Description: Change of use from doctor's practice to 7no. apartment and 1no. studio flat including external extensions and alterations to building.

Site Address: Caxton House Surgery, 53 High Street, Grimethorpe, Barnsley, S72 7BB.

Rev.	Description	By	Date
Project	53 High Street Grimethorpe Barnsley		
Drawing Title	S72 7BB Proposed Elevations		
Drawn by	J.S.	Scale	1:50@A1
Date	Jul '22

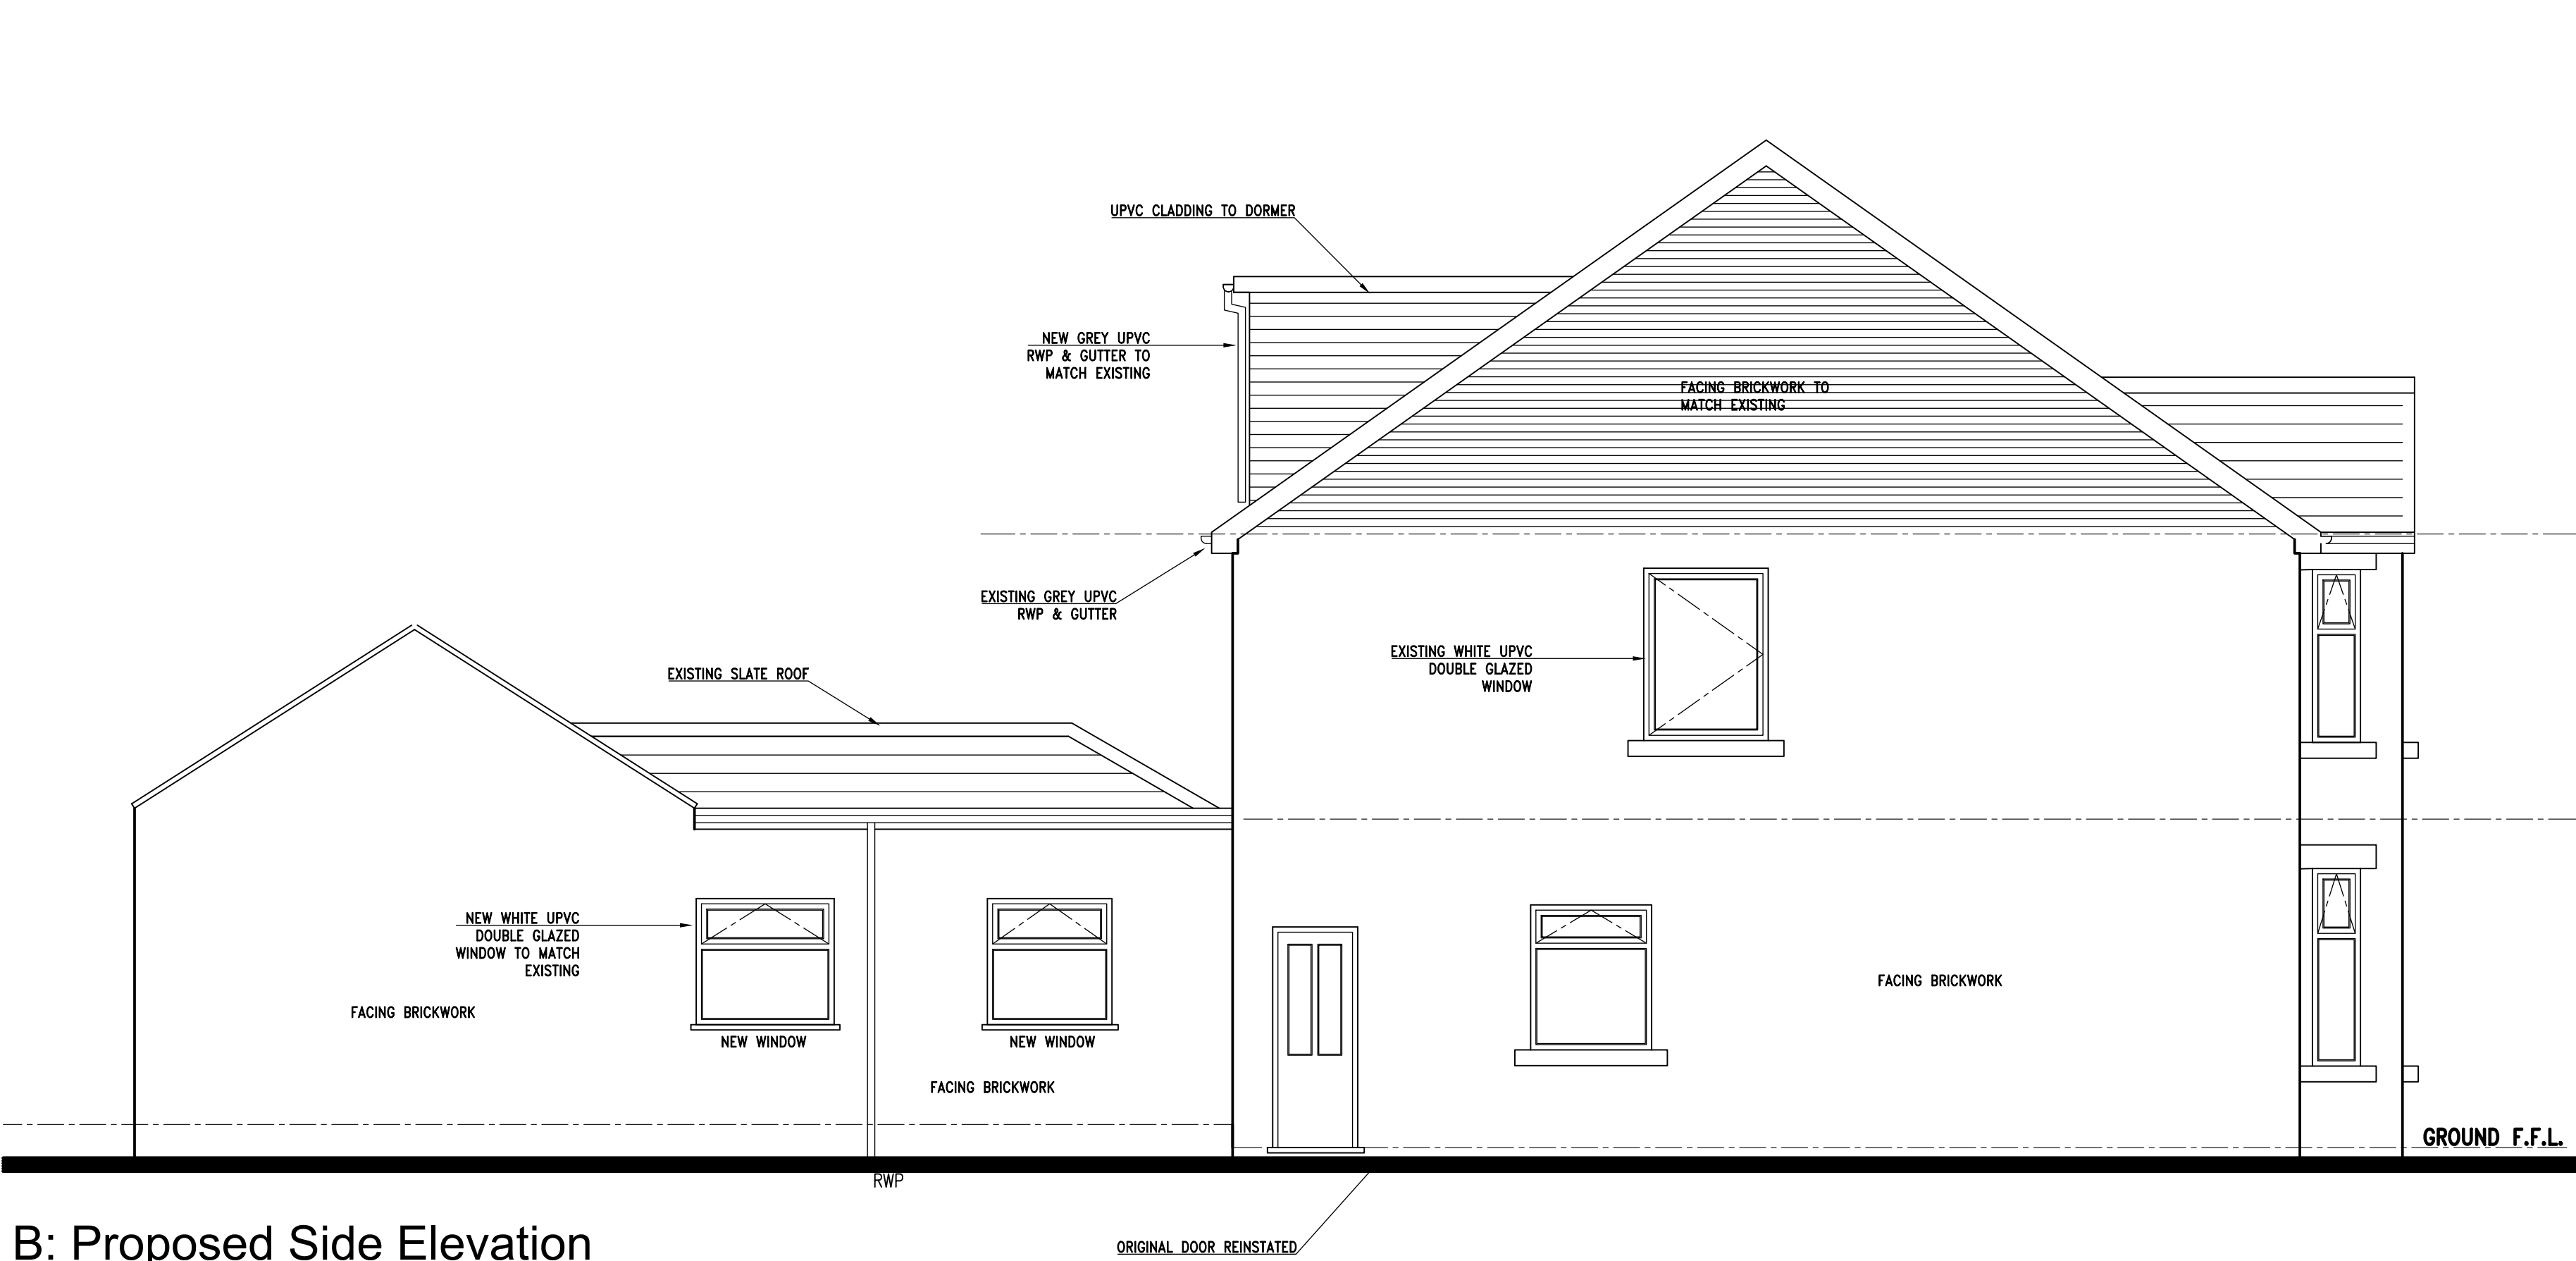
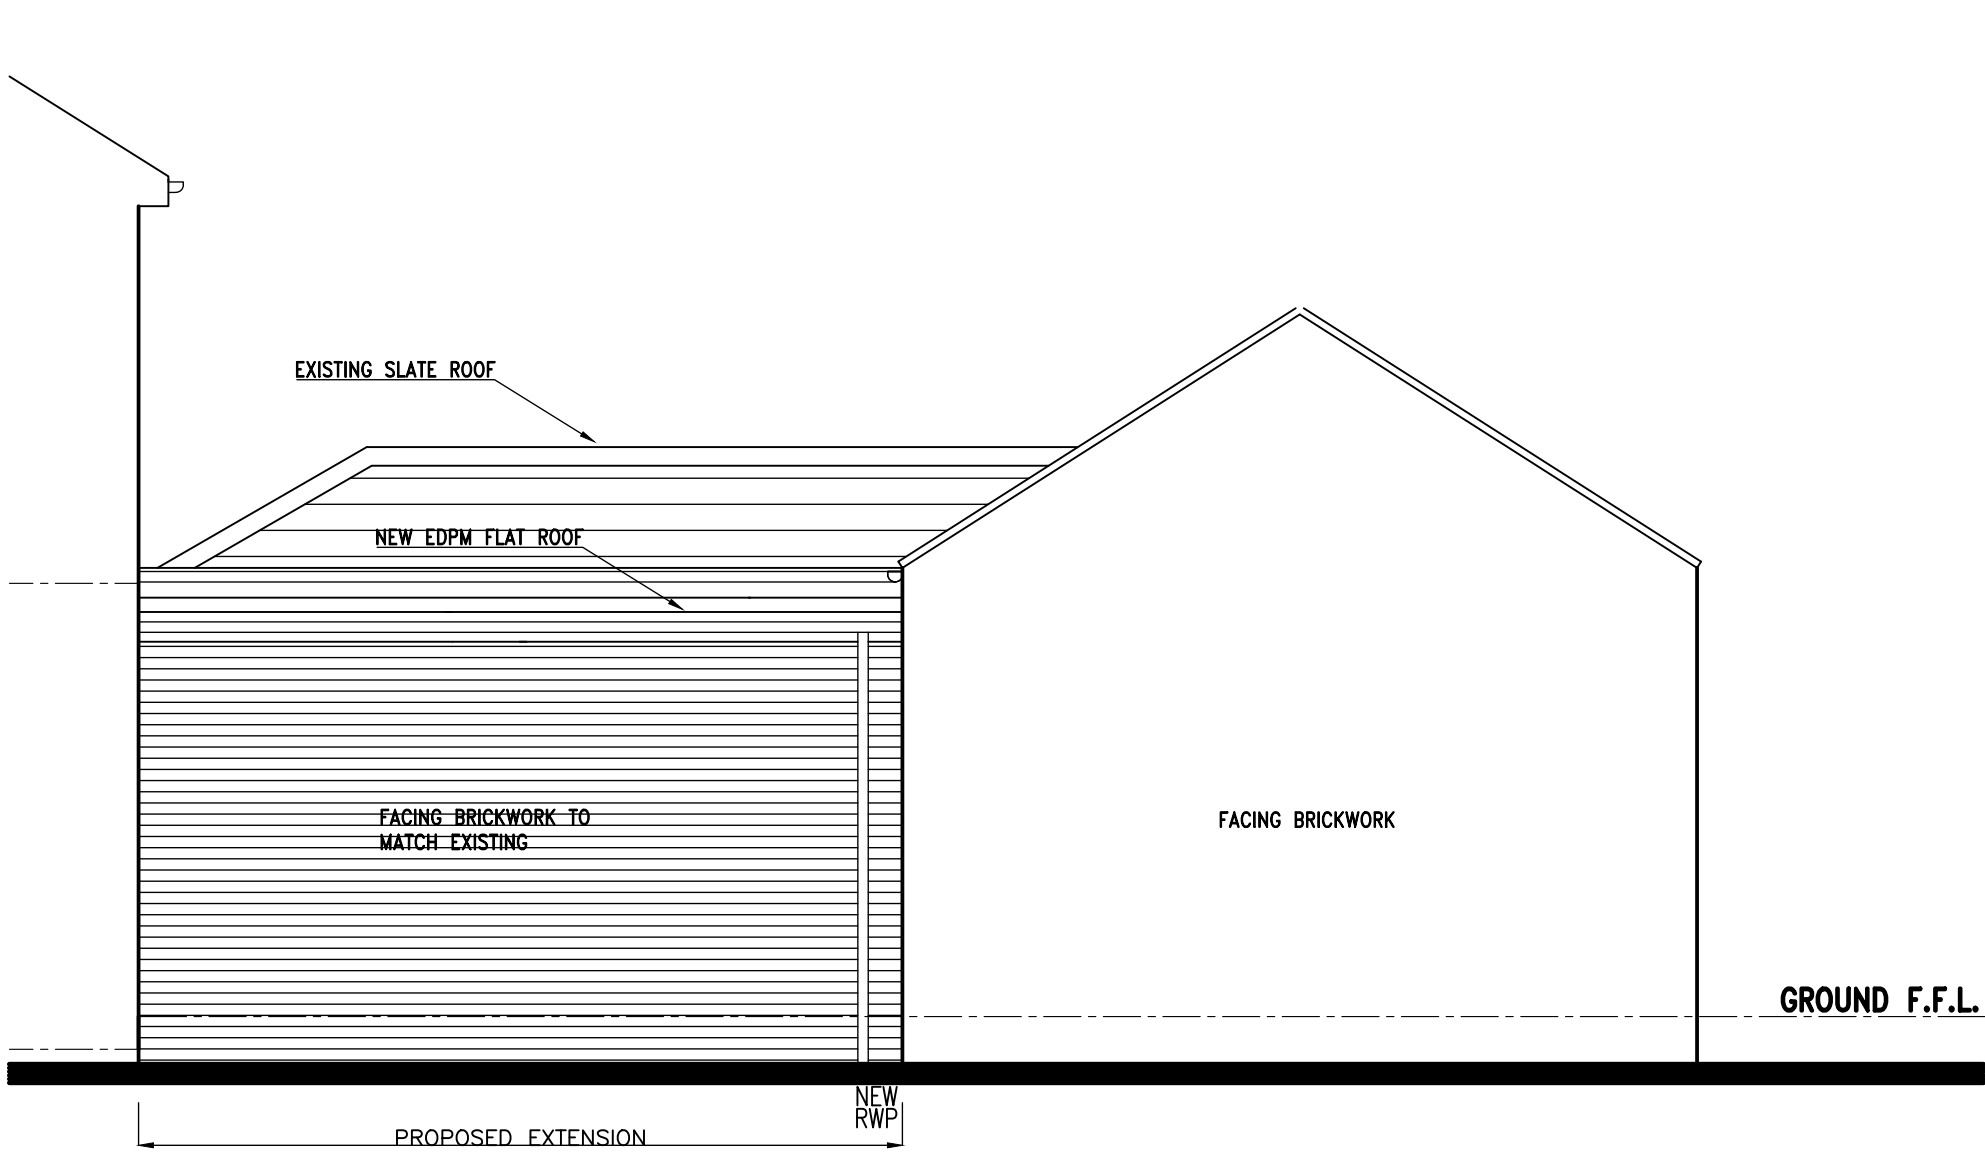
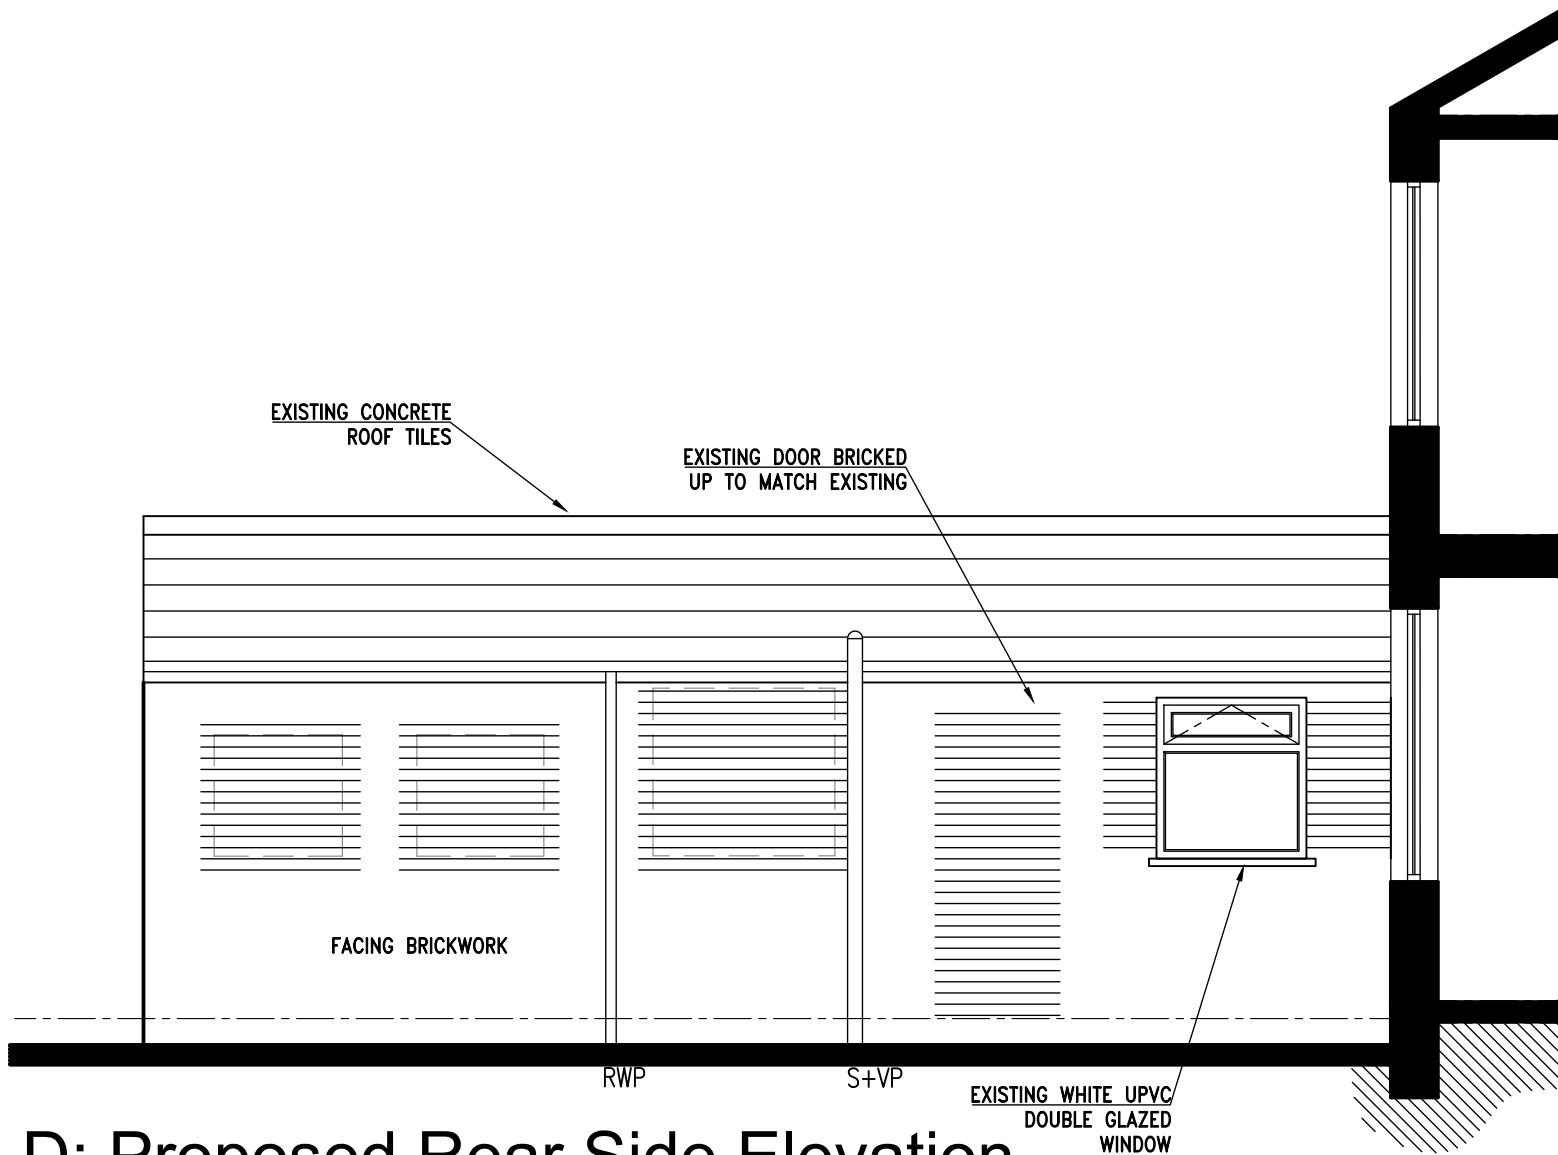
The conversion of the hipped roof to a gable would not increase the height of the roof and would be constructed from matching materials to the existing dwelling. There are existing properties within the immediate street scene with gable roof types and as such it is considered this alteration would be acceptable.

The SPD states that flat roof dormers are considered aesthetically inferior and are not normally acceptable and recommends guidelines which should be followed. The dormer is to the rear of the property and would not be highly visible from public vantage points. It is noted to the rear of the property there are existing garages and no residential properties. In terms of the guidelines the SPD specifies, the proposed dormer sits within the roof plane and the top of the dormer is below the ridge. The dormer is set back from the eaves by 0.46m which is a shortfall of 0.04m in what the guidance specifies and is set in from the adjacent property by 0.28m which is a shortfall of 0.22m. Although there is a small shortfall it is not considered detrimental considering the dormer has been set down and in, would not be highly visible and would again be constructed from matching materials to the existing dwelling.
